DRB Application No.: 09DRB-70276 Project # 1007796
 Project Name: lands of McClain & lands of Williams Andrew McCard
 Agent: Forstbauer Surveying LLC Phone No.: _____

DRB Comments

Re: Replat of Tract 2, Lands of McClain and Tract A-3, Lands of William Andrew McCord (reconfiguration of lot lines to create 2 tracts from 2 existing tracts)

Tracts 1 & 2 Lands of Accion New Mexico

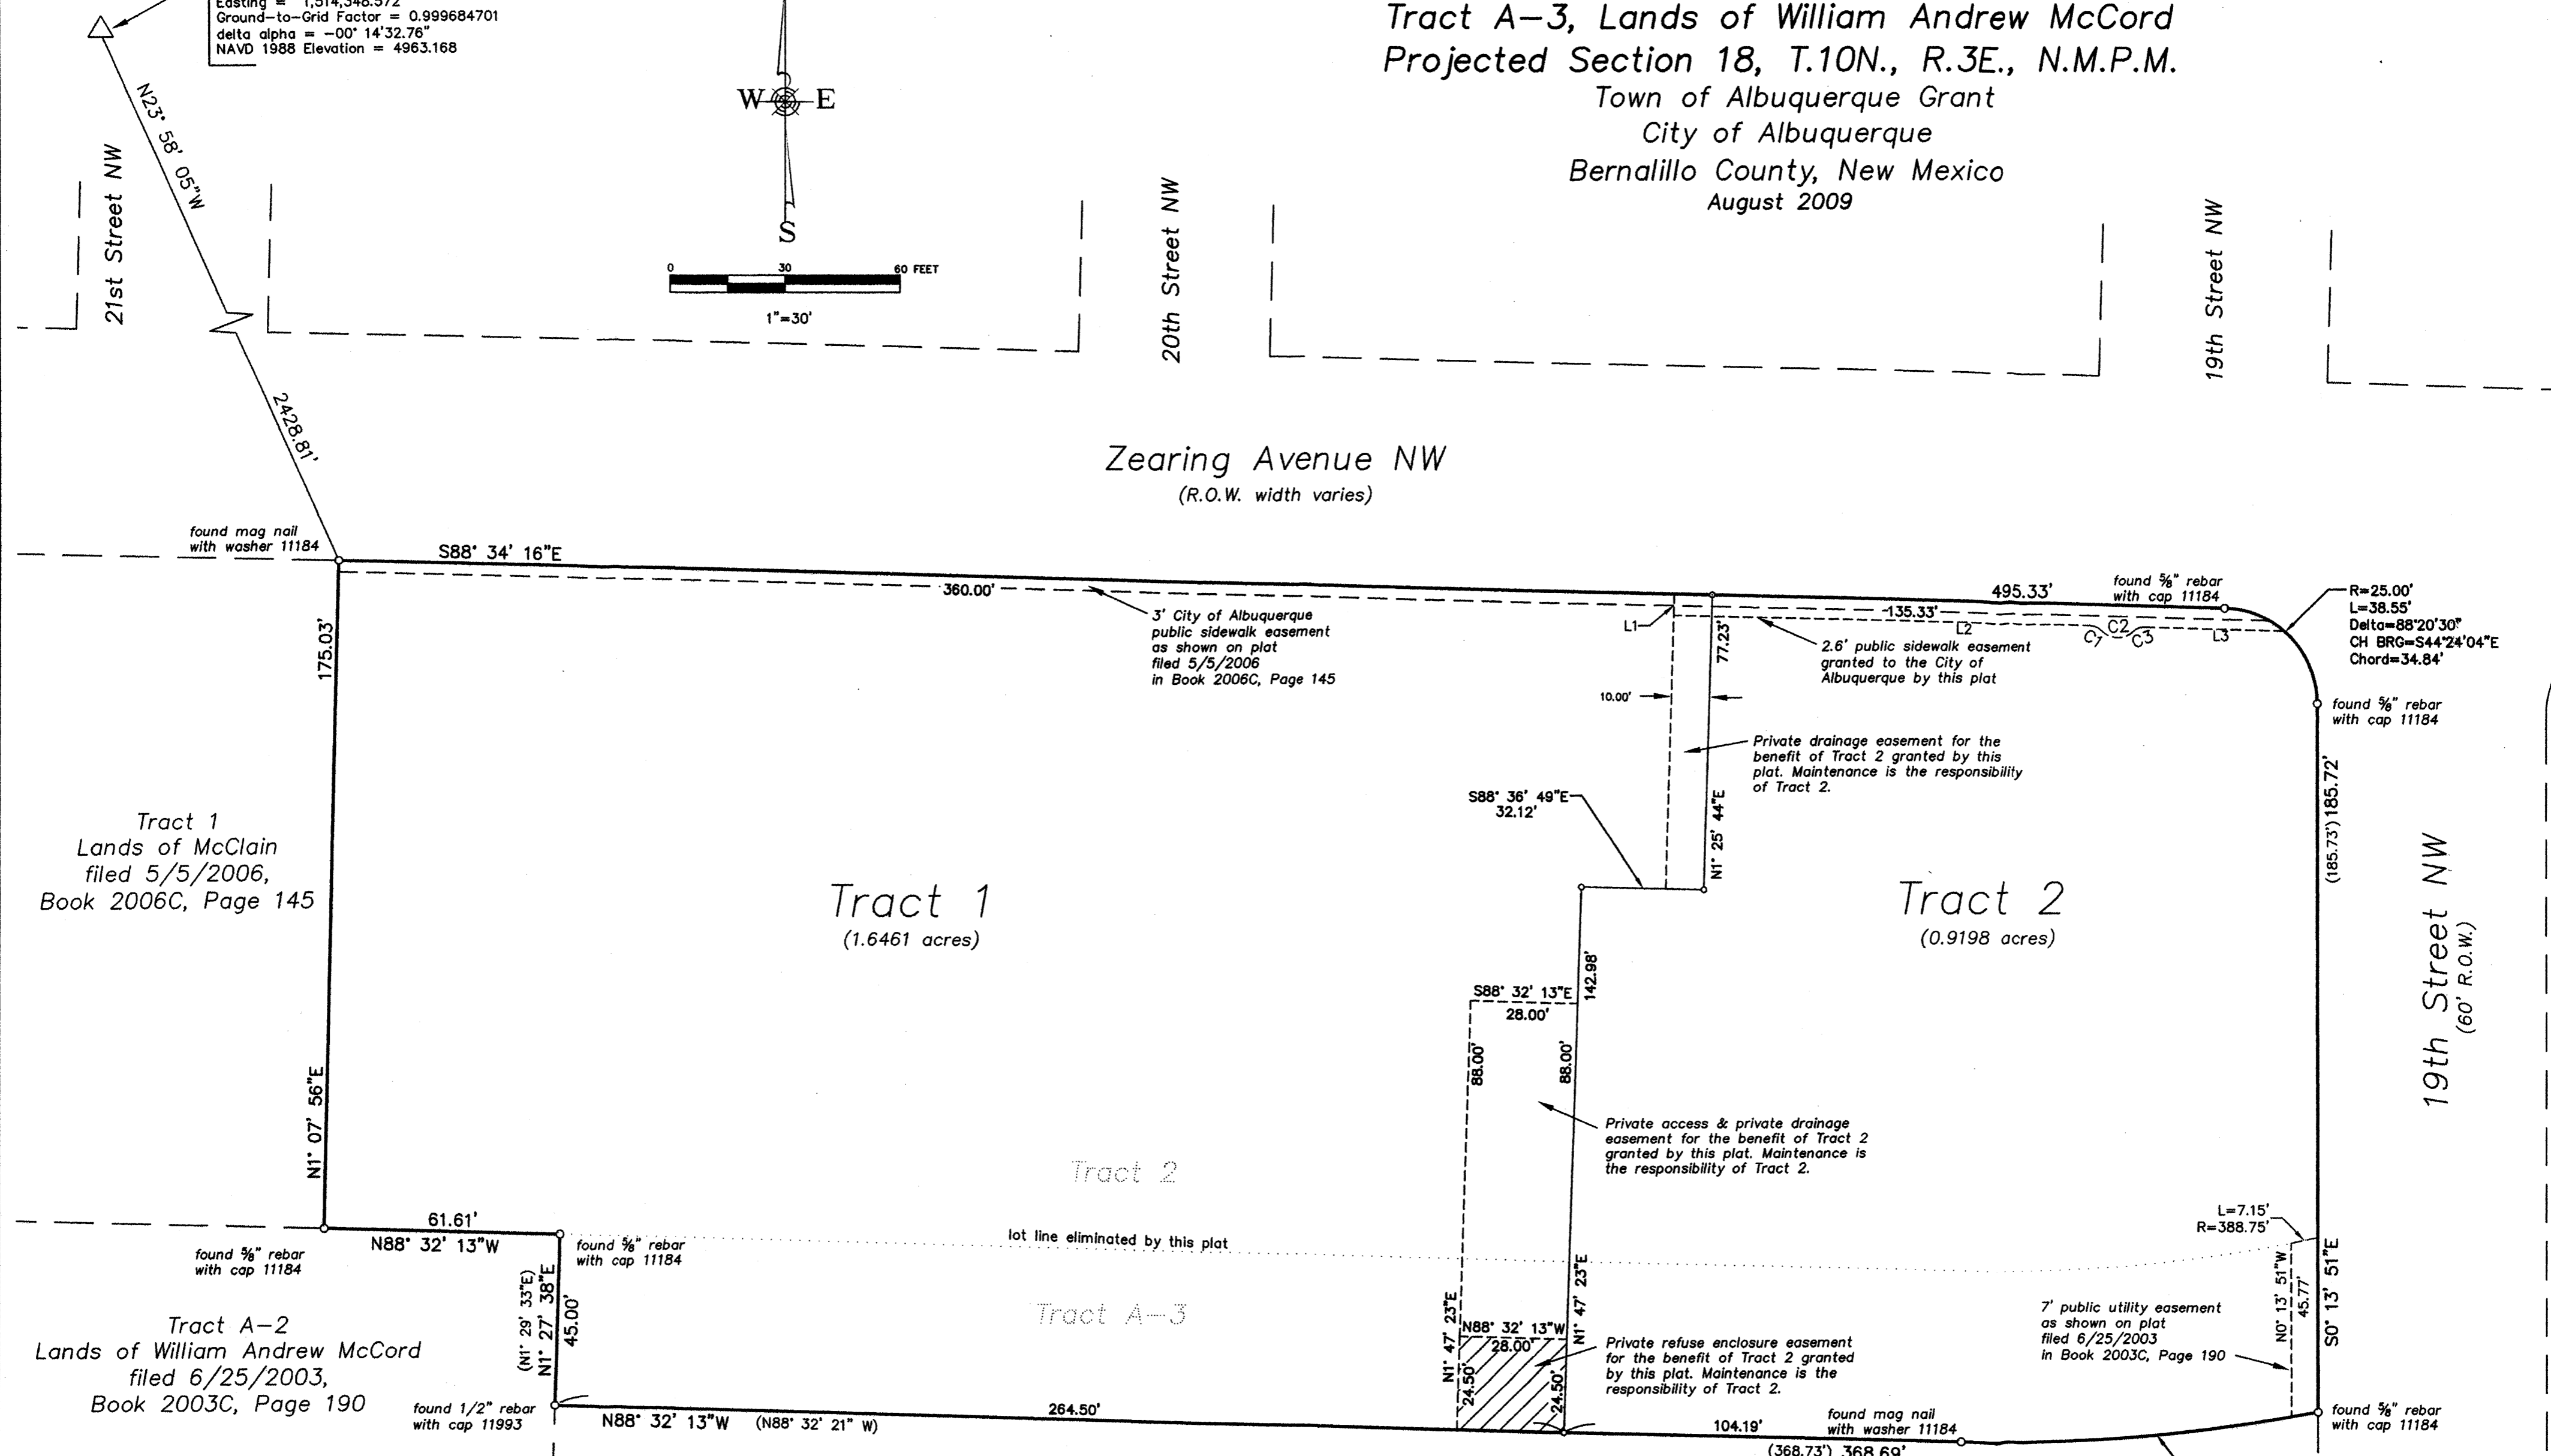
I am attaching a pdf with a proposed sidewalk easement (within Tract 2 and the adjacent drainage easement) added. A sidewalk easement was not a Transportation requirement at the August 26 DRB hearing but was requested by you in a letter to the architect, Christopher Gunning, Dekker Perich Sabatini, in a letter dated August 17, 2009 (Re: Accion New Mexico Regional Headquarters, 2000 Zearing Avenue NW, Traffic Circulation Layout).

The issue of the additional sidewalk easement did not come up at DRB because the existing sidewalk is located within public right of way / sidewalk easement. The proposed sidewalk for the Accion NM Regional Headquarters will require an additional sidewalk easement. I have reviewed your attached drawing and agree with the proposed layout of the sidewalk easement. Once the plat has been recorded, please provide a copy for my files.
